1034 MCGARRY TERRACE
Urban Design Review Panel Report

Prepared for:
Kionas Construction Ltd.

Reference: 1034 McGarry Terrace Response to UDRP Planning Recommendations

sheet no.:  
**A402(W)**

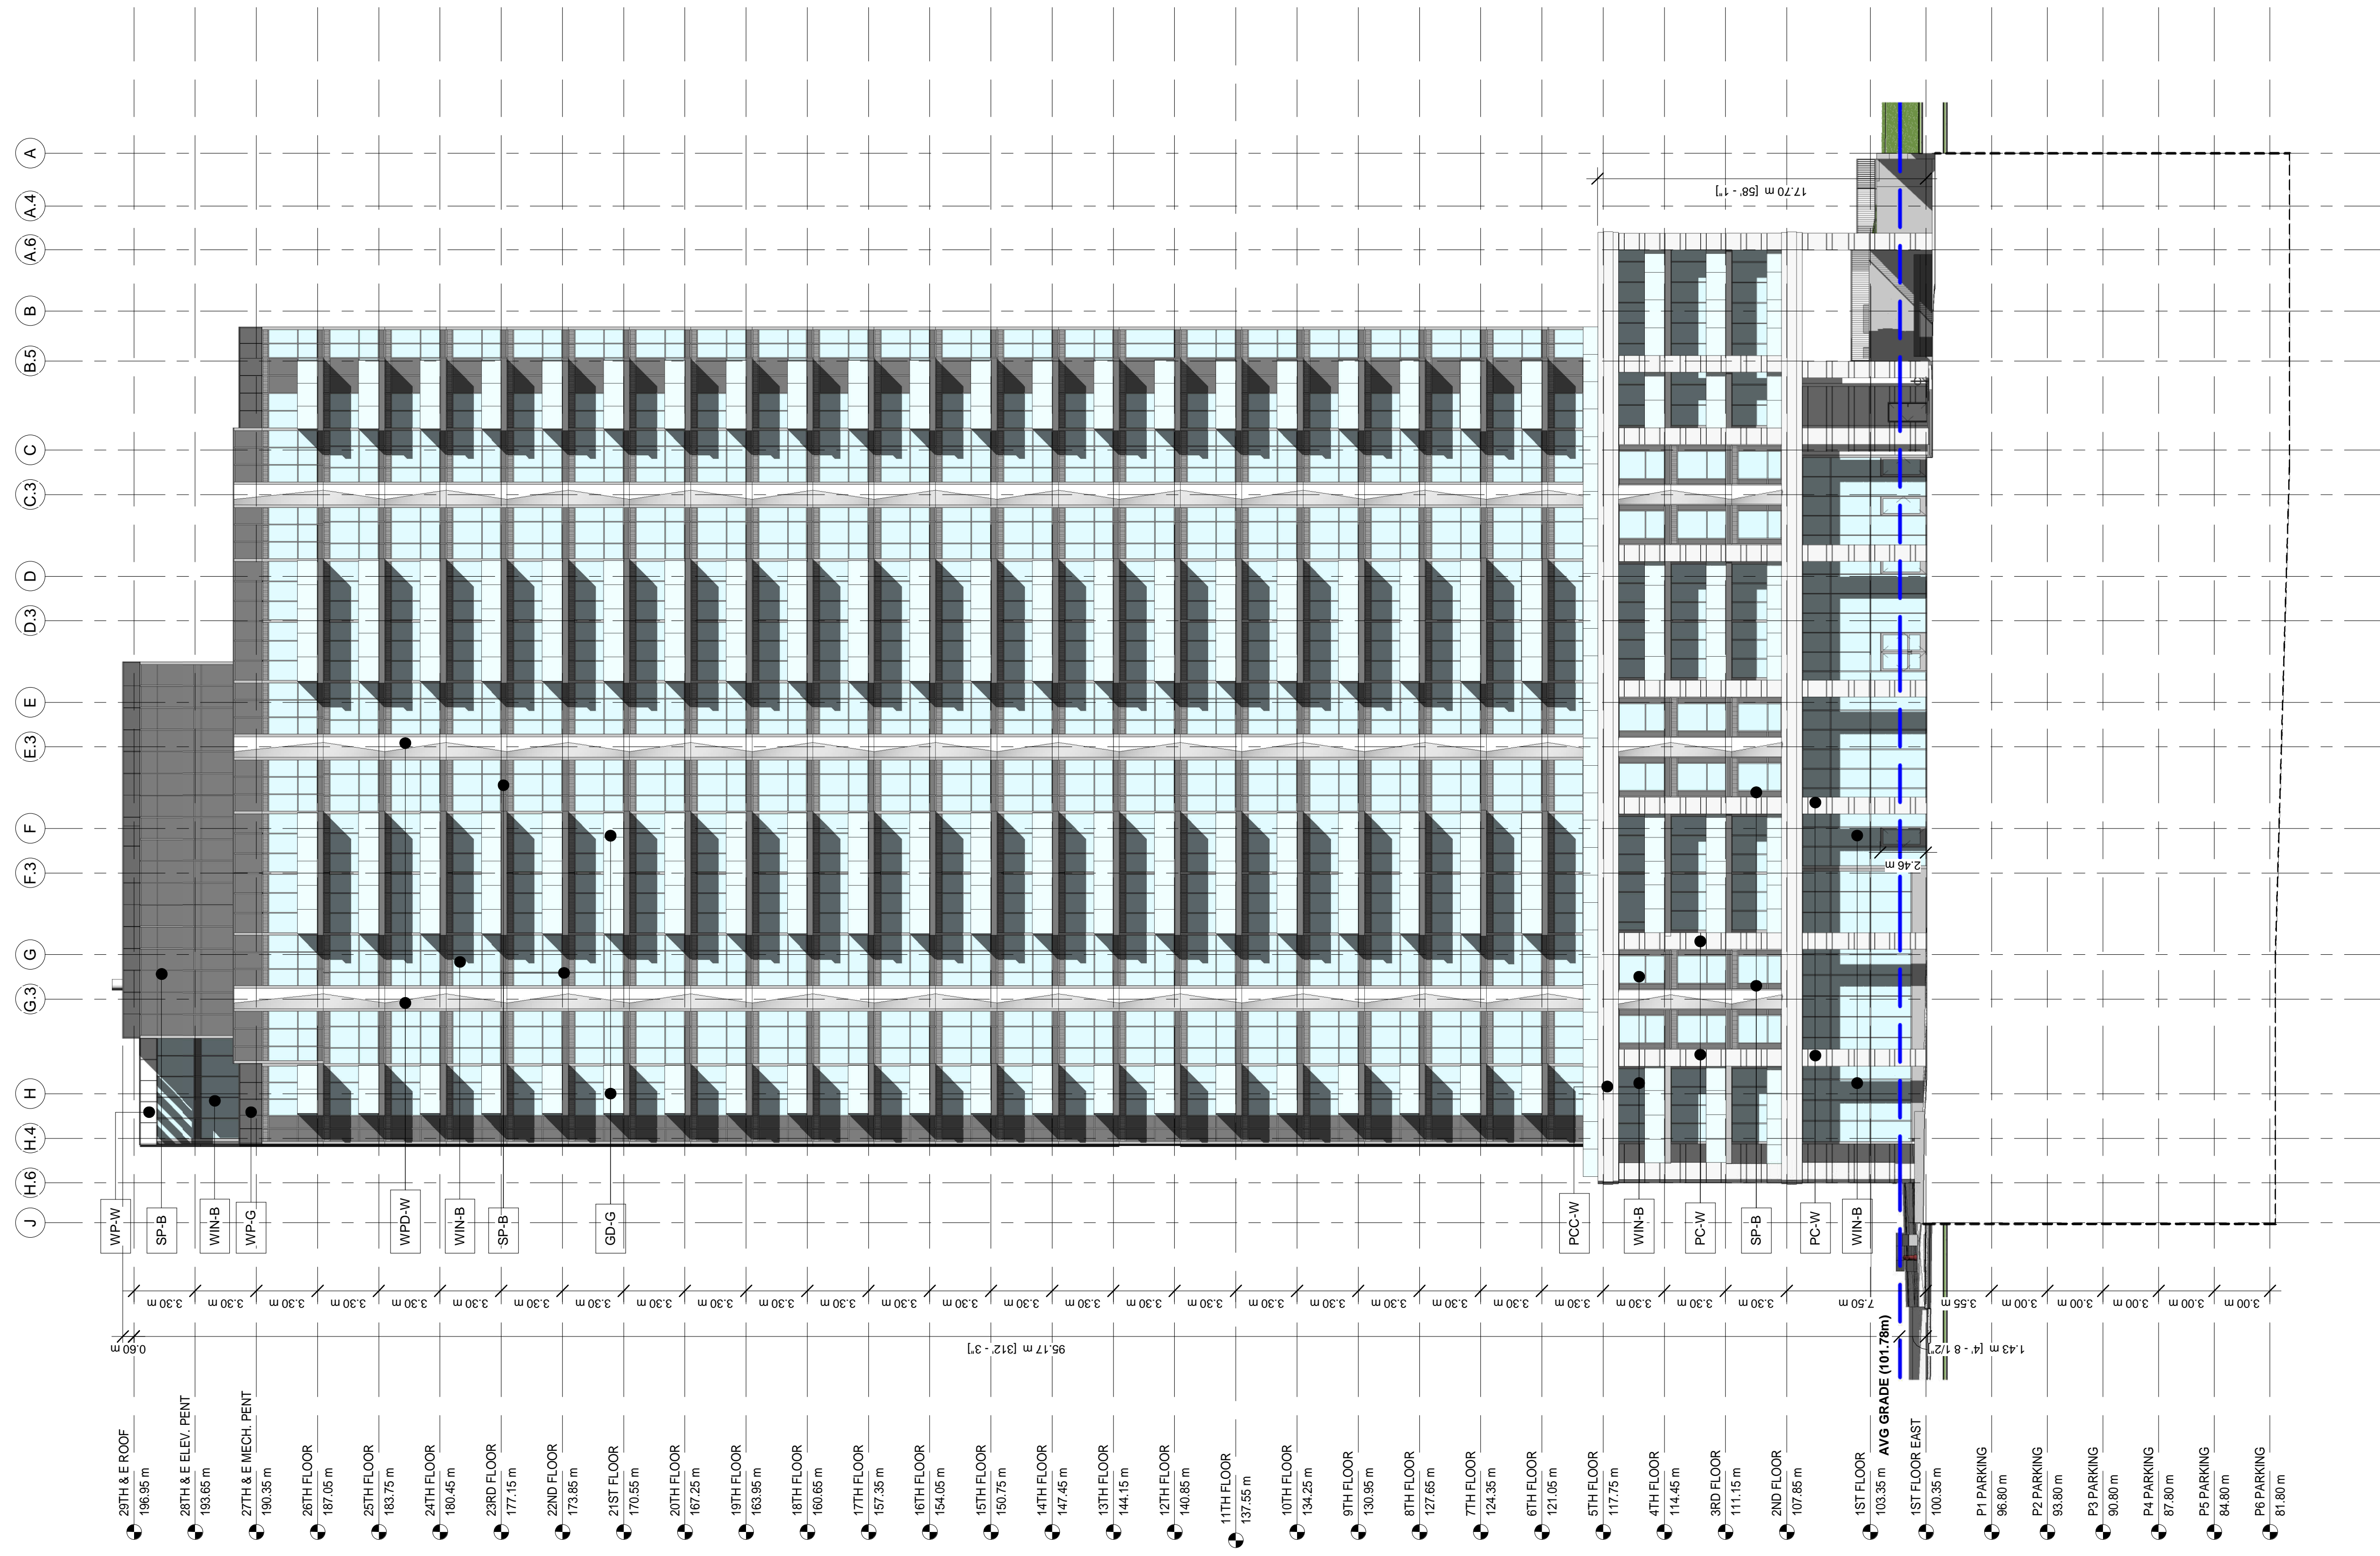
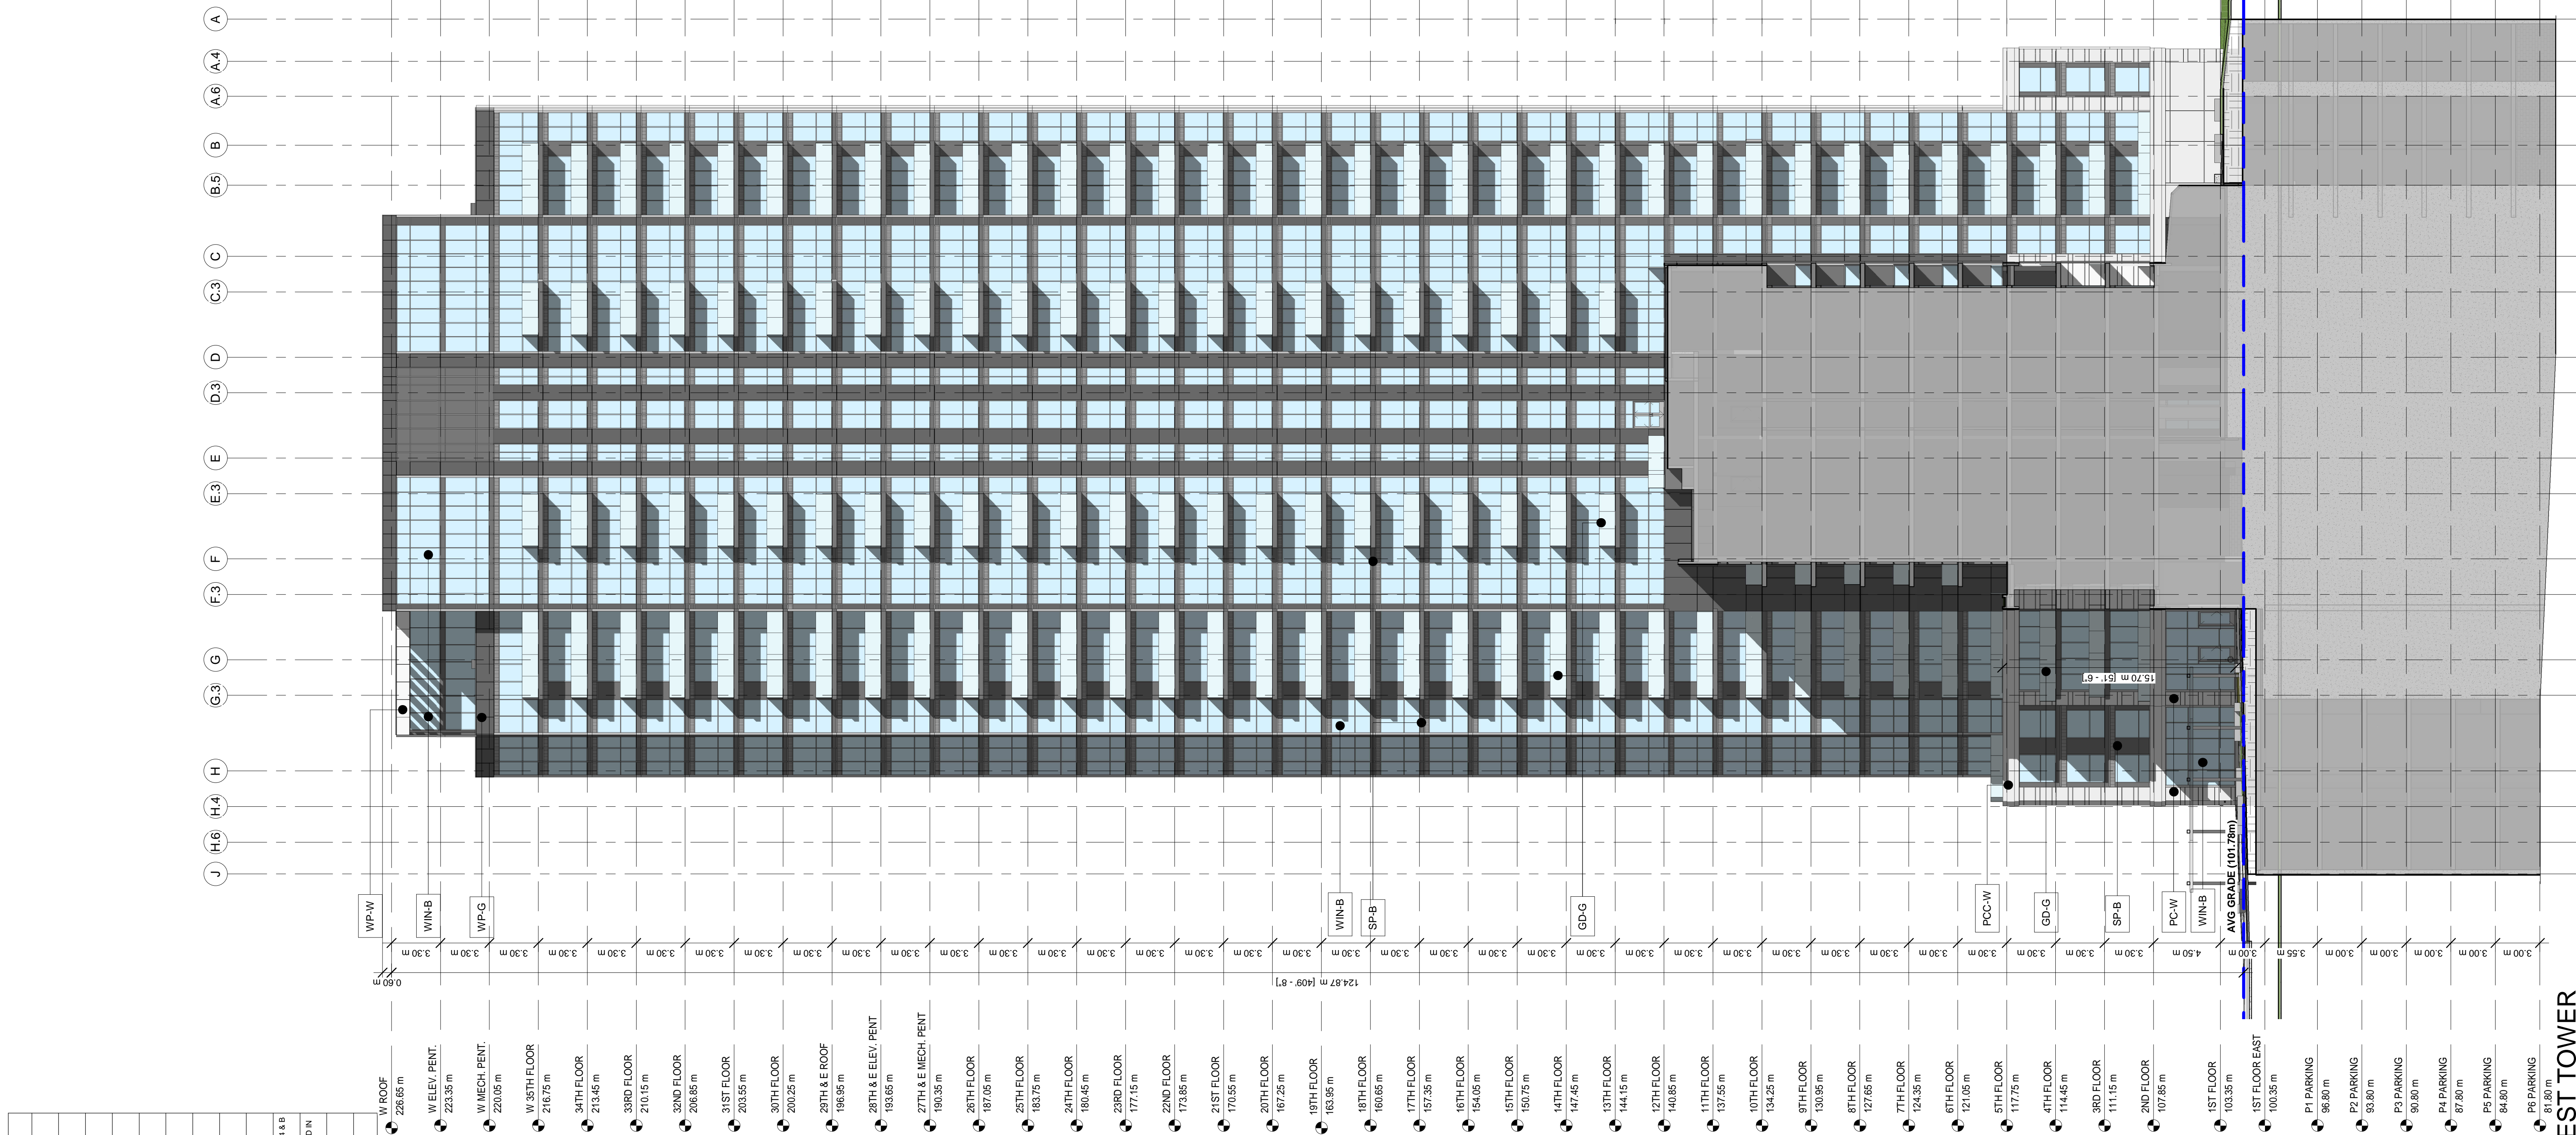
The Panel supports the current proposed massing over the previous studies shown in the presentation.	Acknowledged.
The Panel has strong concerns regarding the size of the floorplates proposed. <ul style="list-style-type: none">The Panel recommends reducing the floorplates to a maximum size of 750 square metres, as per the City of Ottawa guidelines	The towers propose floorplates of 750 and 765 m ² and are consistent with the design guidelines.
The Panel recommends investigating the possibility of a 35-metre separation between the two towers. <ul style="list-style-type: none">Consider tower separation as a remedy to wind-tunnelling and improving the micro-climate of the POPS.	Tower floorplates have been reduced to the extent feasible to increase tower separation distances and increase step-backs. Tower heights have also been reduced to reduce wind tunnelling.
The Panel recommends staggering the heights of the towers to a more appropriate scale and transition from the surrounding context. <ul style="list-style-type: none">Consider a 30-storey tower on the west side nearest to McGarry Terrace, and a shorter tower closer to 20-storeys on the east side	To ensure that there is variation in height between the two towers, it is proposed that the west tower be reduced to 35 storeys in height, whereas the east tower would be reduced to 26 storeys.
